CITY OF ALBUQUERQUE

April 13, 2022

Re: FNHC Behavioral Health Outpatient Clinic
5110 Copper Ave. NE
Traffic Circulation Layout
Architect's Stamp 04-04-2022 (K17-D118)

SITE PLAN • REFUSE ENCLOSURE LAYOUT

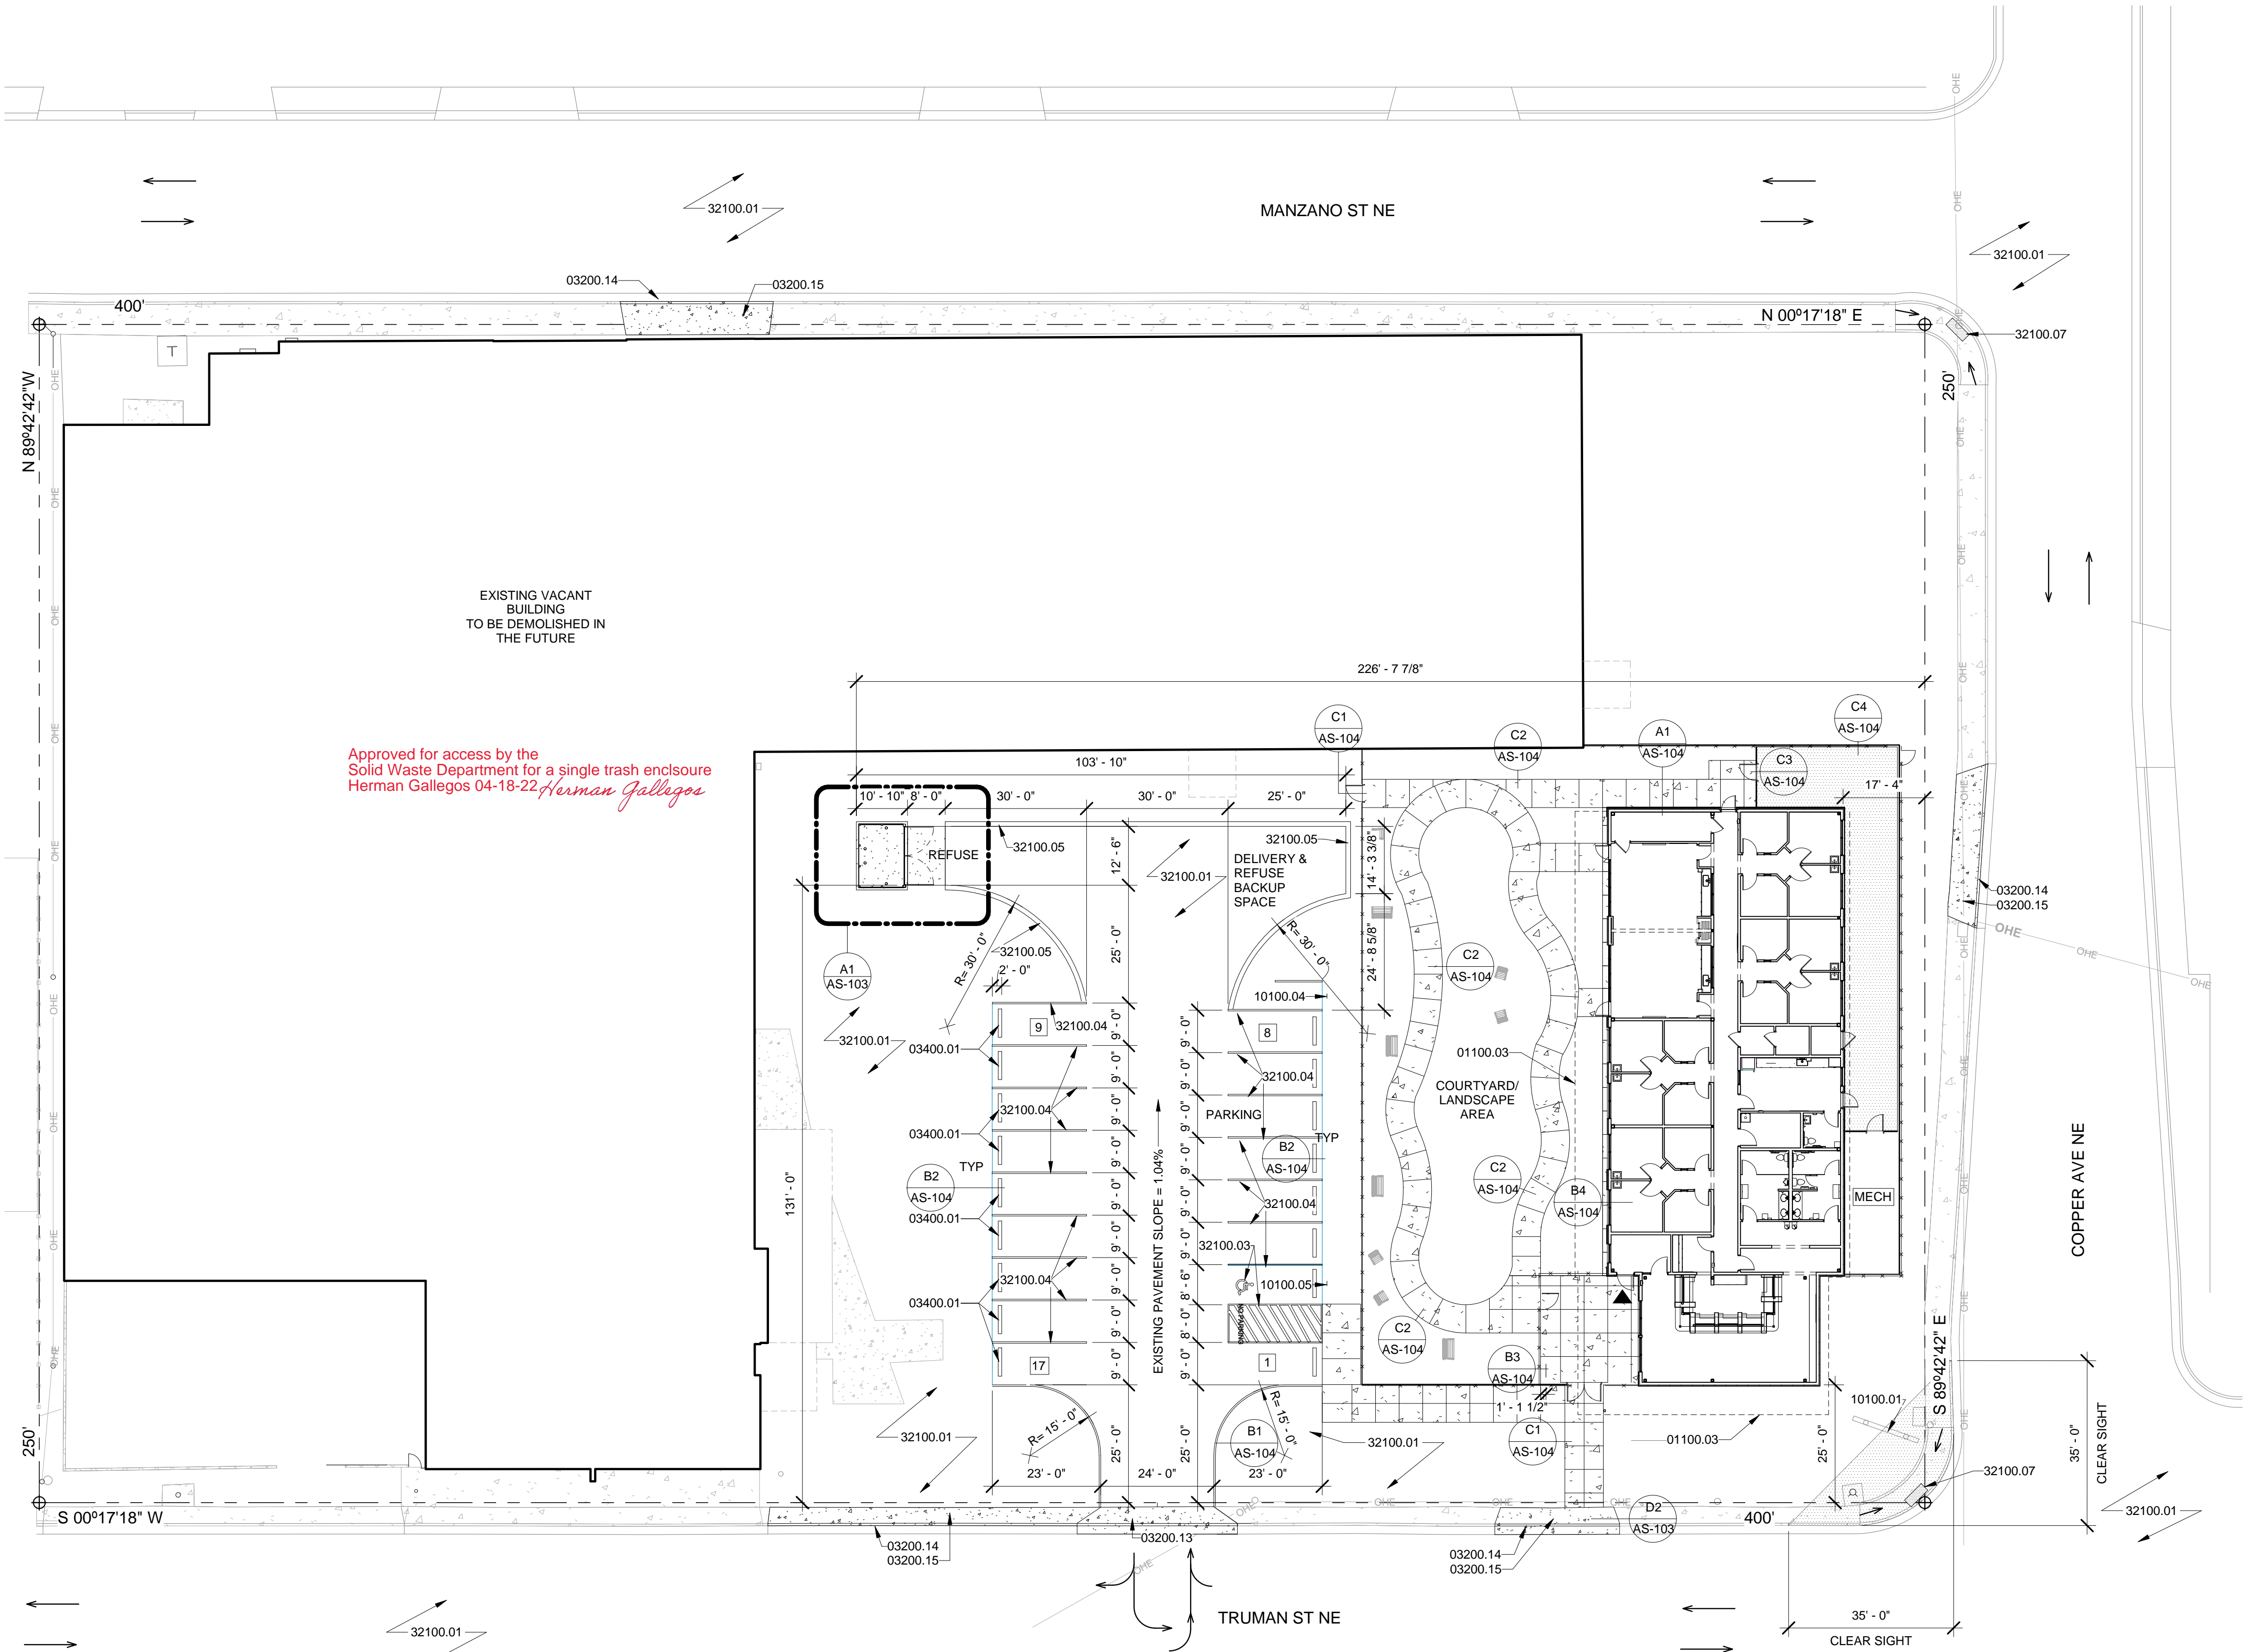
24. Provide a copy of refuse approval.
25. Fire Department: An approval Fire 1 plan needs to be provided.
26. Please provide a sight distance exhibit
27. Show the clear sight triangle and add the following note to the plan: "Landscaping and signage will not interfere with clear sight requirements. Therefore, signs, walls, trees, and shrubbery between 3 and 8 feet tall (as measured from the gutter pan) will not be acceptable in the clear sight triangle.

TRAFFIC CIRCULATION LAYOUT PLAN

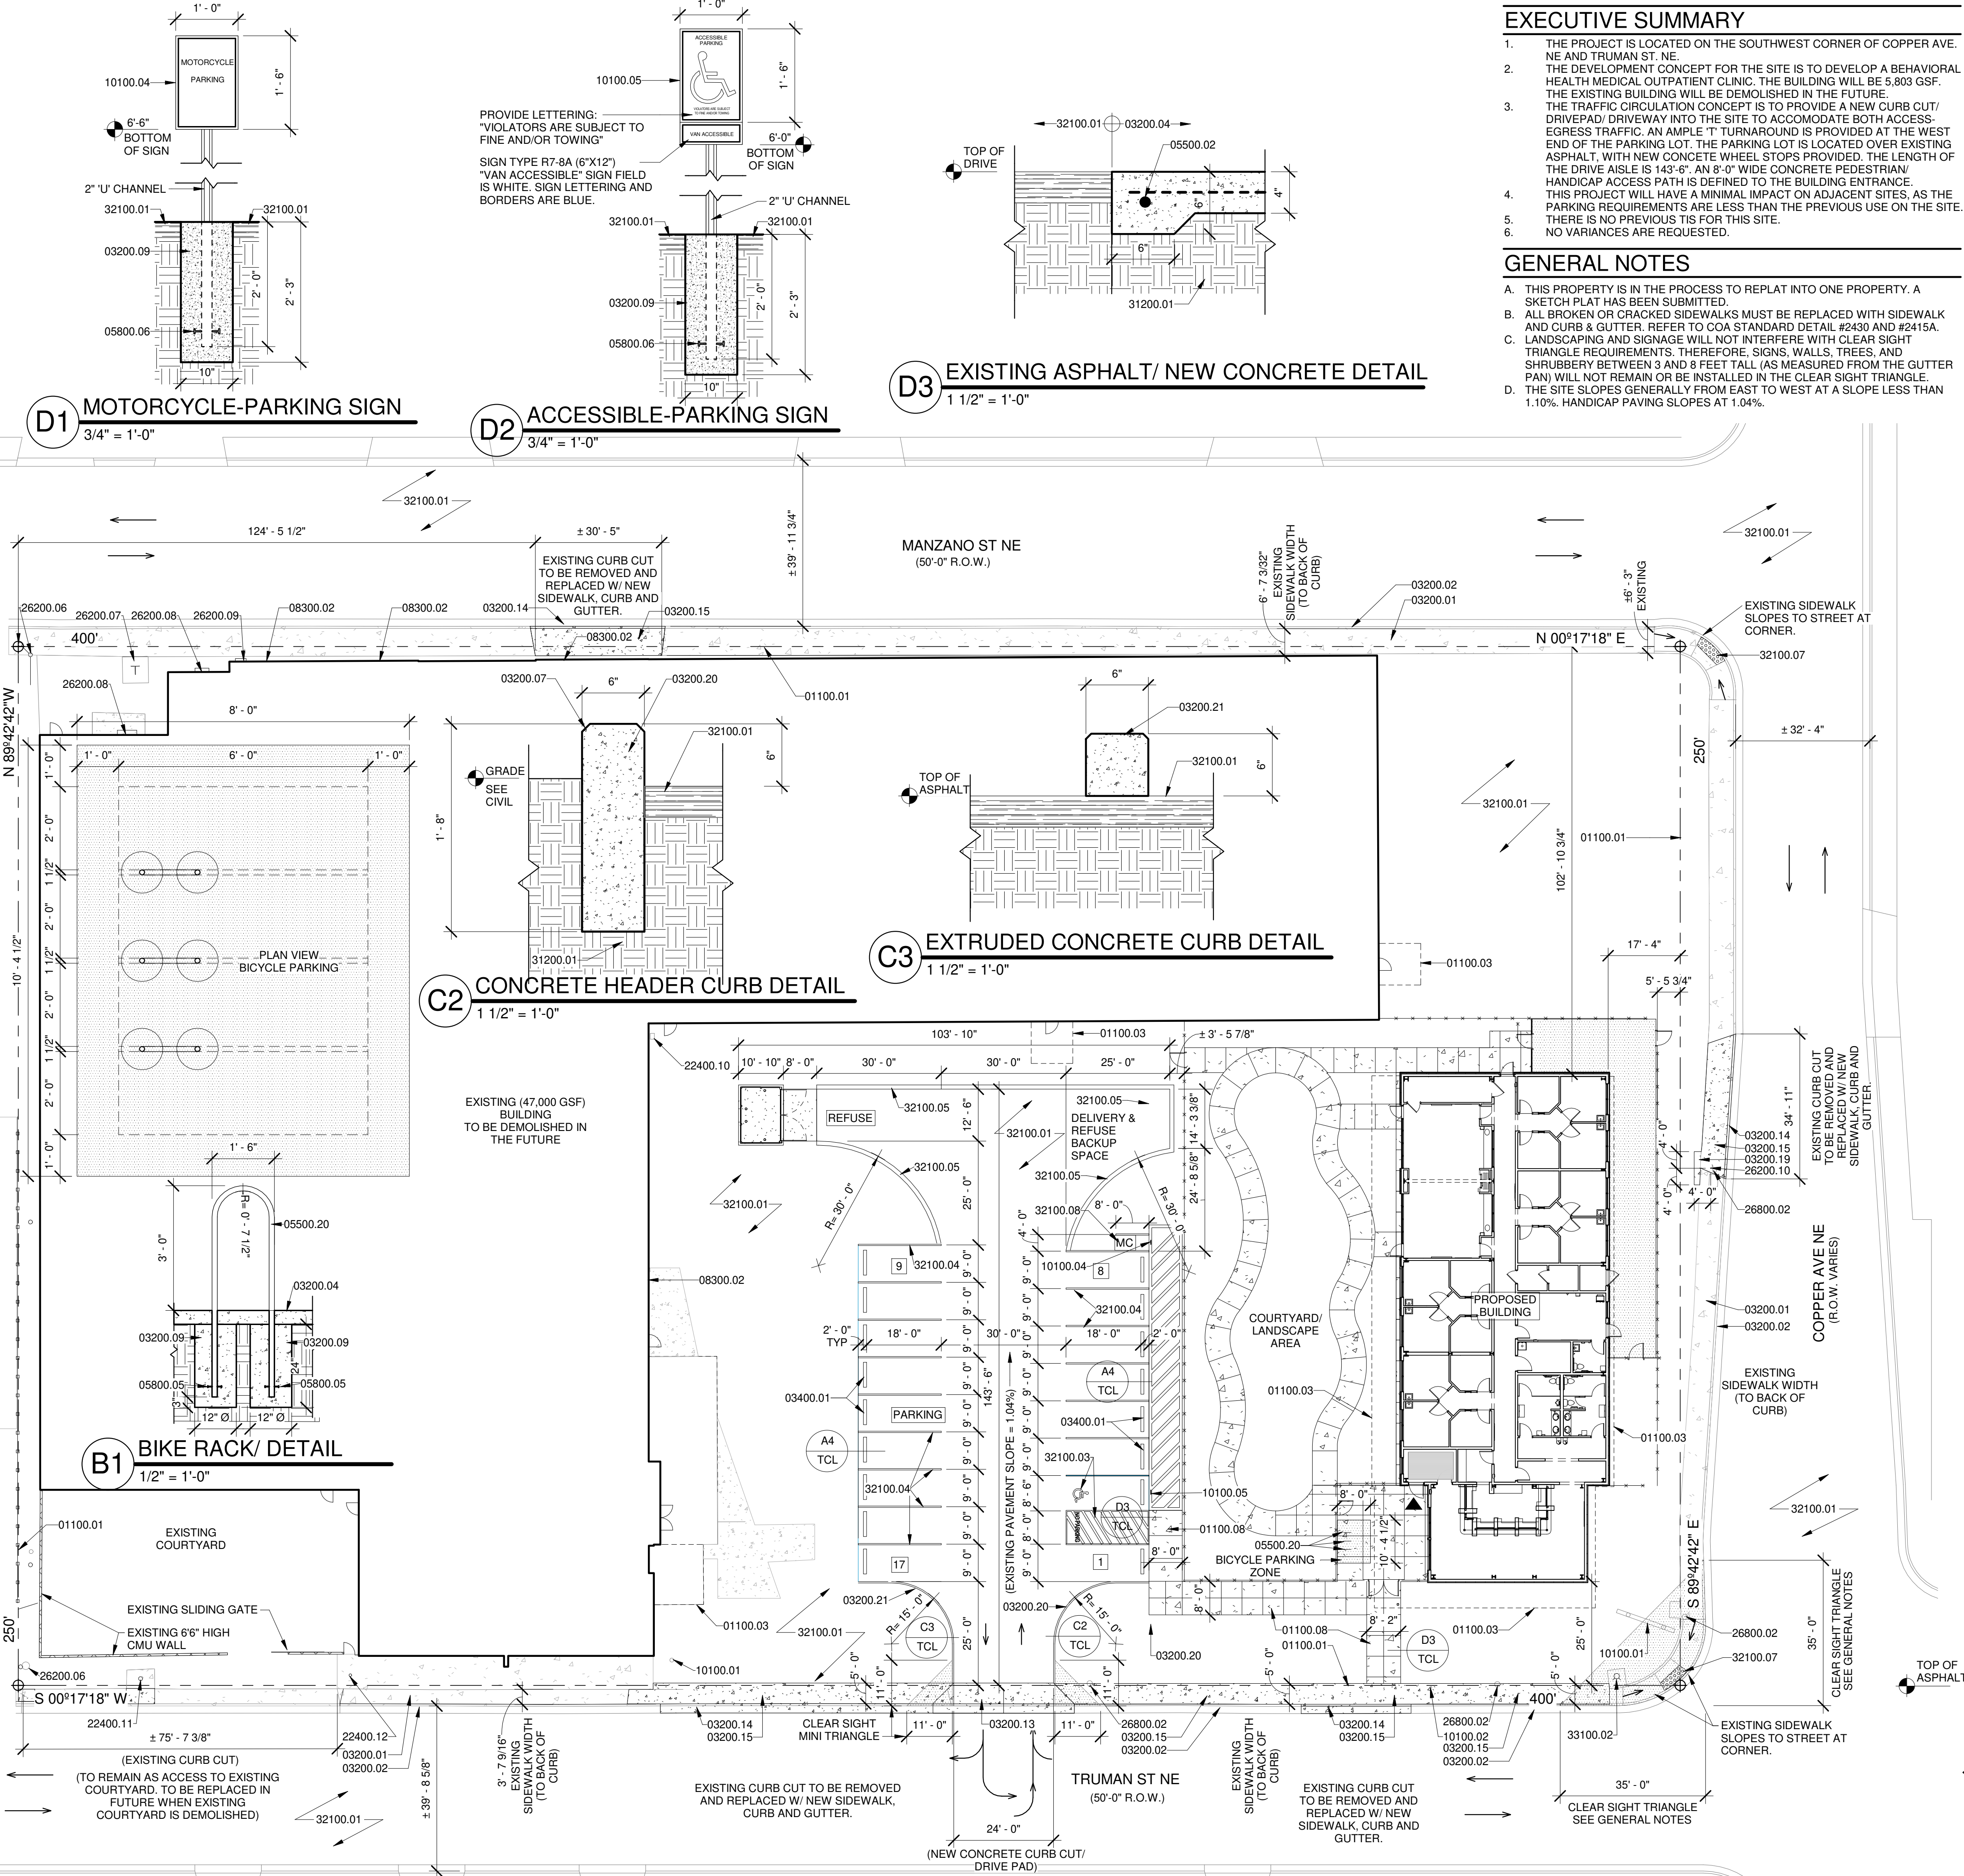
1. Listed are the number of parking spaces required by the IDO as well as the proposed number of parking spaces including bicycle and motorcycle parking.
Coordinate/discuss with Zoning.
2. AGIS shows 4 existing lots on the property but your site plan does not. So, please clear up this concern or else you will need a shared access agreement between all 4 lots.
3. All public infrastructure (sidewalk/ramp) located outside of public ROW will need a **Sidewalk Easement.**
4. Public sidewalk existing and fronting site will need widths provided.
5. Identify all existing access easements.
6. Identify the right of way width, medians, curb cuts, and **street widths** on Copper, Manzano and Truman. You show the roadway widths but labeled as ROW width. ROW widths are measure from property line to property line.
7. Maximum access width for arterial, collector, and local streets are as follows:

8. The maximum allowable driveway entrance width off Truman is 24ft and not the proposed 40ft.
9. A detail will be needed for the proposed driveway entrance and/or reference COA std dwg 2425.

11. ADA parking stall width (as shown above) will need to be **8.5' wide**.
12. The ADA accessible parking sign must have the required language per 66-7-352.4C NMSA 1978 **"Violators Are Subject to a Fine and/or Towing."** Please call out detail and location of signs.

13. The ADA access aisles shall have the words **"NO PARKING"** in capital letters, each of which shall be at least one foot high and at least two inches wide, placed at the rear of the parking space so as to be close to where an adjacent vehicle's rear tire would be placed. (66-1-4.1.B NMSA 1978) . Please details for striping and pavement marking for the text.

14. **Motorcycle parking space:** shall be designated by its own conspicuously posted upright sign, either free-standing or wall mounted per the zoning code. Label pavement MC.

20. Per the DPM, a 6 ft. wide ADA accessible pedestrian pathway is required from the public sidewalk to the building entrances. **Please clearly show this pathway and provide details.**

21. Per DPM, a 6 ft. wide ADA accessible pedestrian pathway is required from the ADA parking stall access aisles to the building entrances. **Please clearly show this pathway and provide details. Pathway will need to be concrete and not asphalt as labeled.**

22. All sidewalks along streets should be placed at the property line.
23. Curbing should be installed to delineate landscape, parking, and pedestrian ways and identify points of access. Please call out **detail and location of barrier curb.**

30. Unused curb cuts must be replaced with sidewalk and curb & gutter. **A build note must be provided referring to the appropriate City Standard drawing (2430 & 2415A).**

31. The existing curb cuts off Copper and Manzano will need to be closed. Please provide construction note for closure or explain why they should remain.

32. Add a note stating "All broken or cracked sidewalk must be replaced with sidewalk and curb & gutter." **A build note must be provided referring to the appropriate City Standard drawing (2430 & 2415A).**
